Response to ExA Questions Round 1

SUBJECT: Immingham Green Energy Terminal

APPLICANT: Associated British Ports

**NORTH EAST LINCOLNSHIRE
COUNCIL**

**FIGURE TITLE**  
 Viewpoint Locations

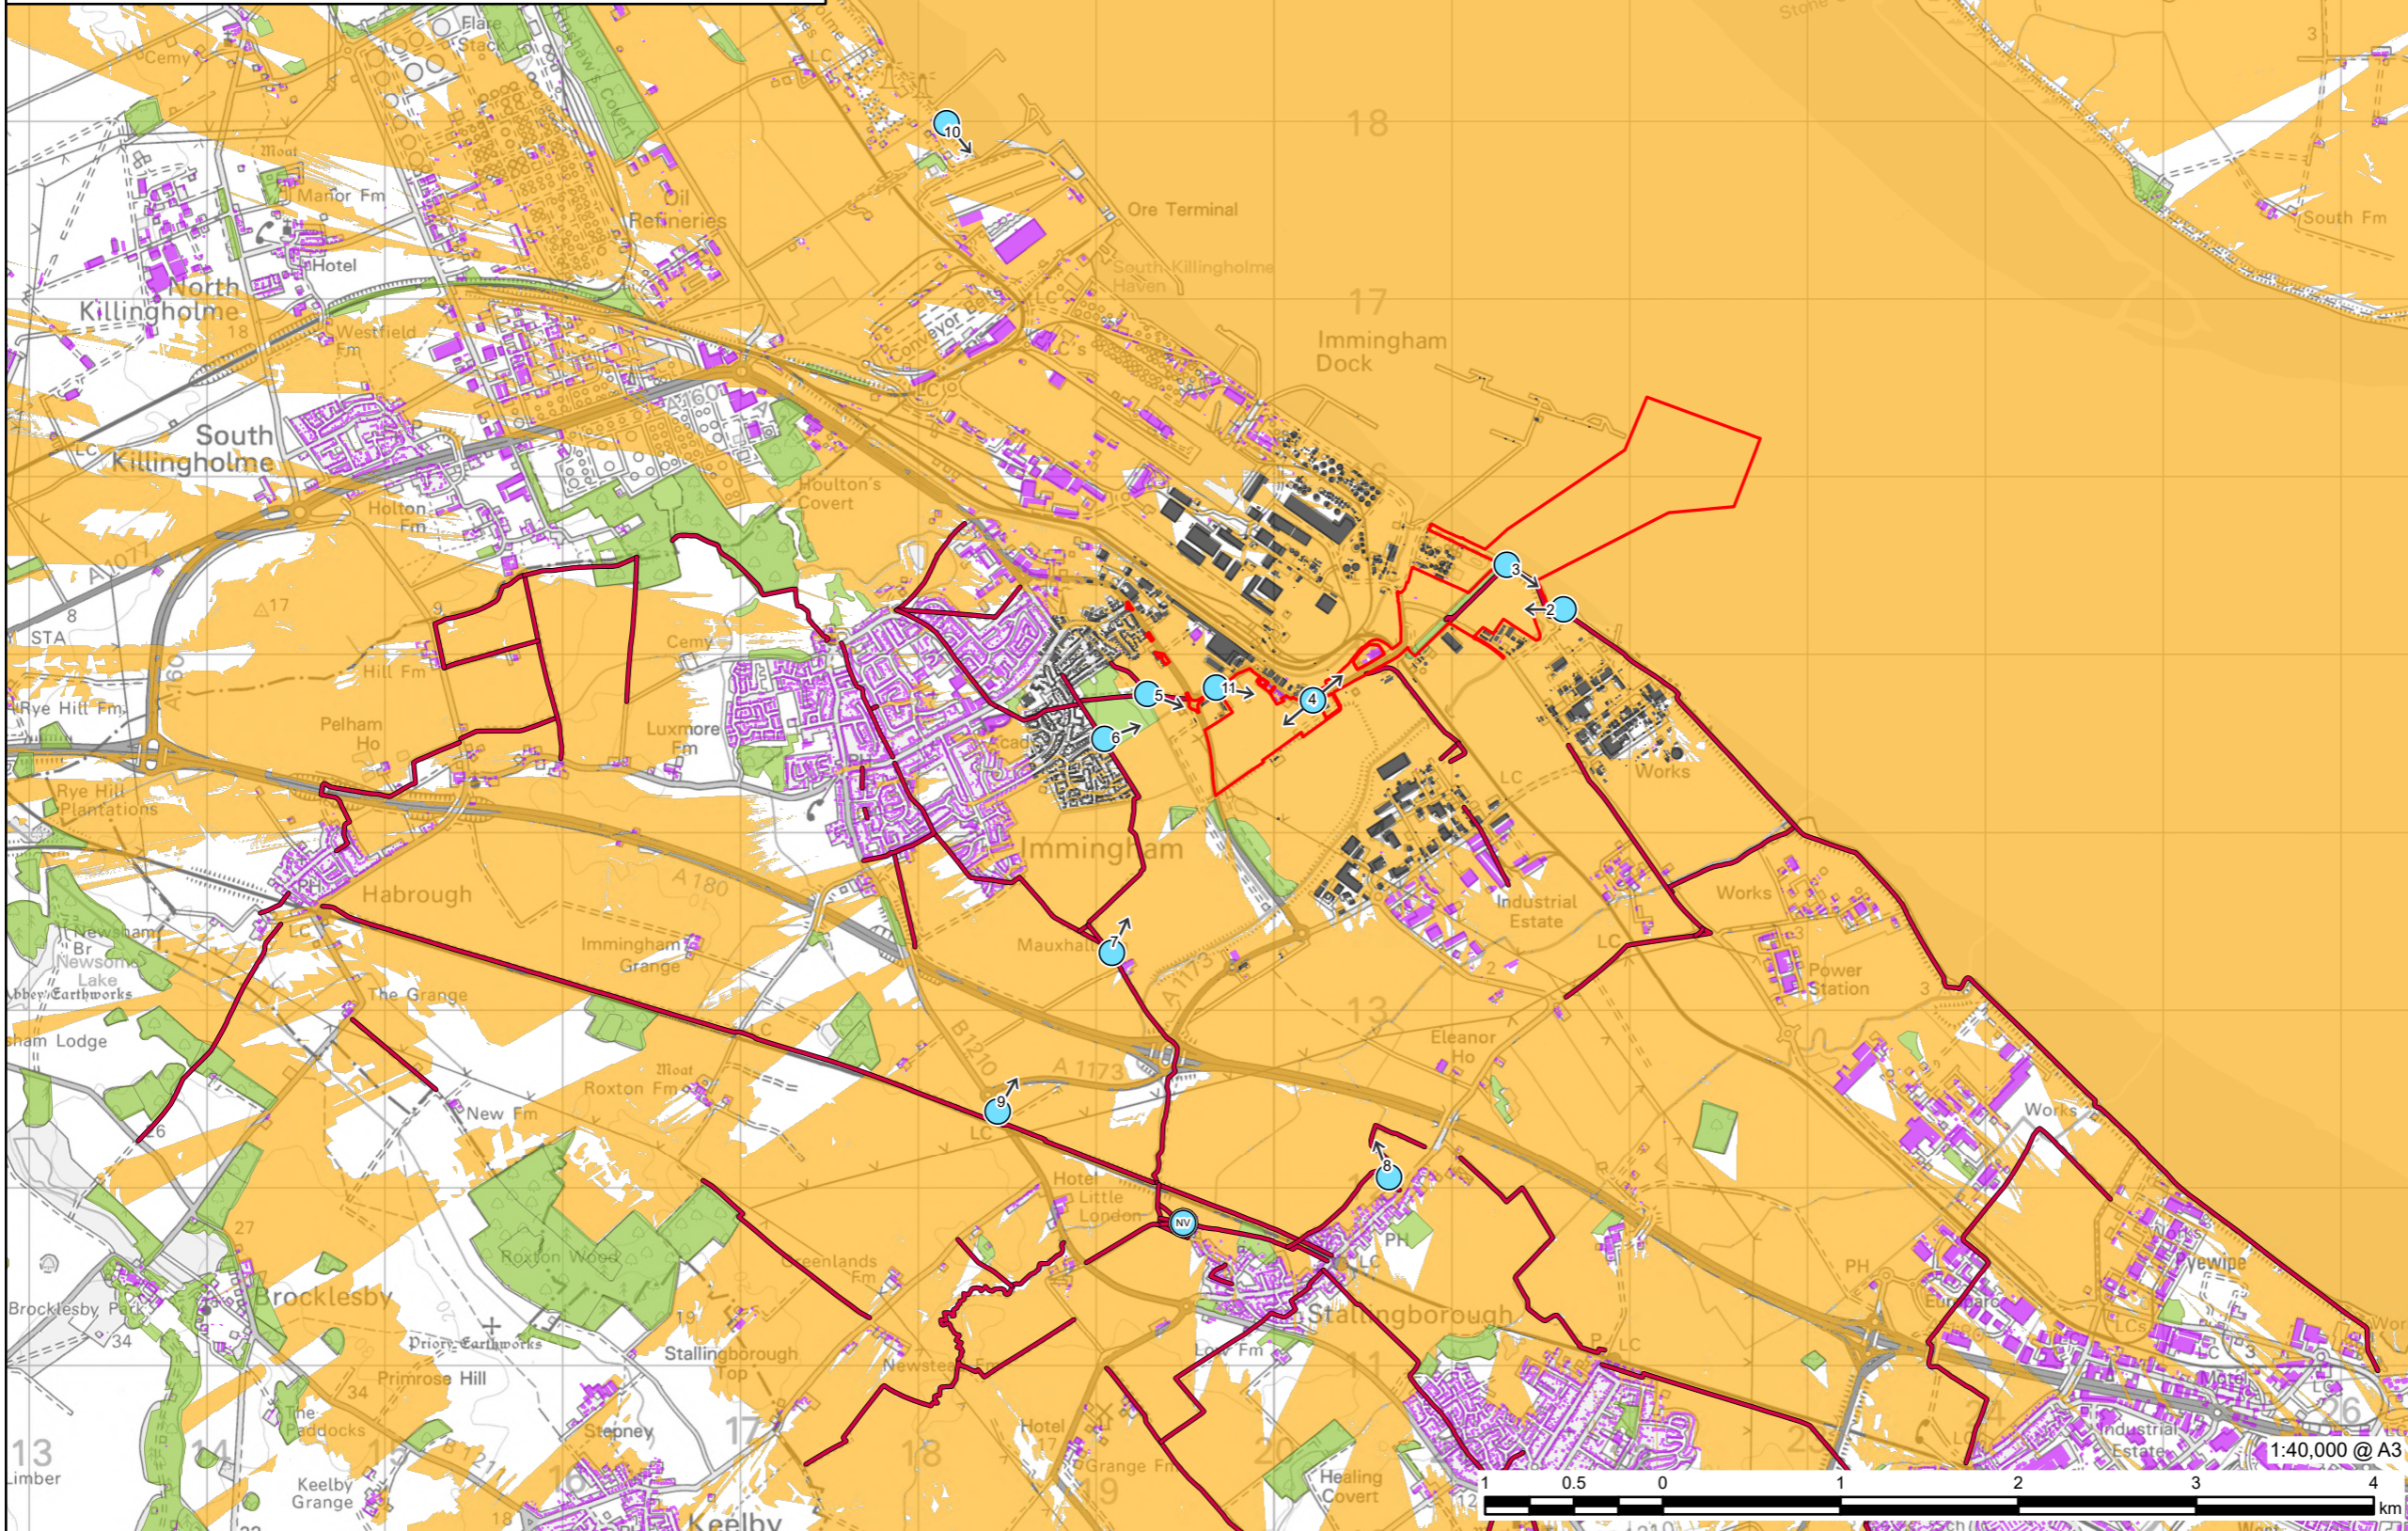
- a) NELC broadly agree with the assessments in this section.
- b) NELC Consider that additional points may be of benefit for views from the Lincolnshire Wolds National Landscape/AONB.

- b) NELC agree that additional photomontages would be beneficial for points 3 and 11 but consider no others required.
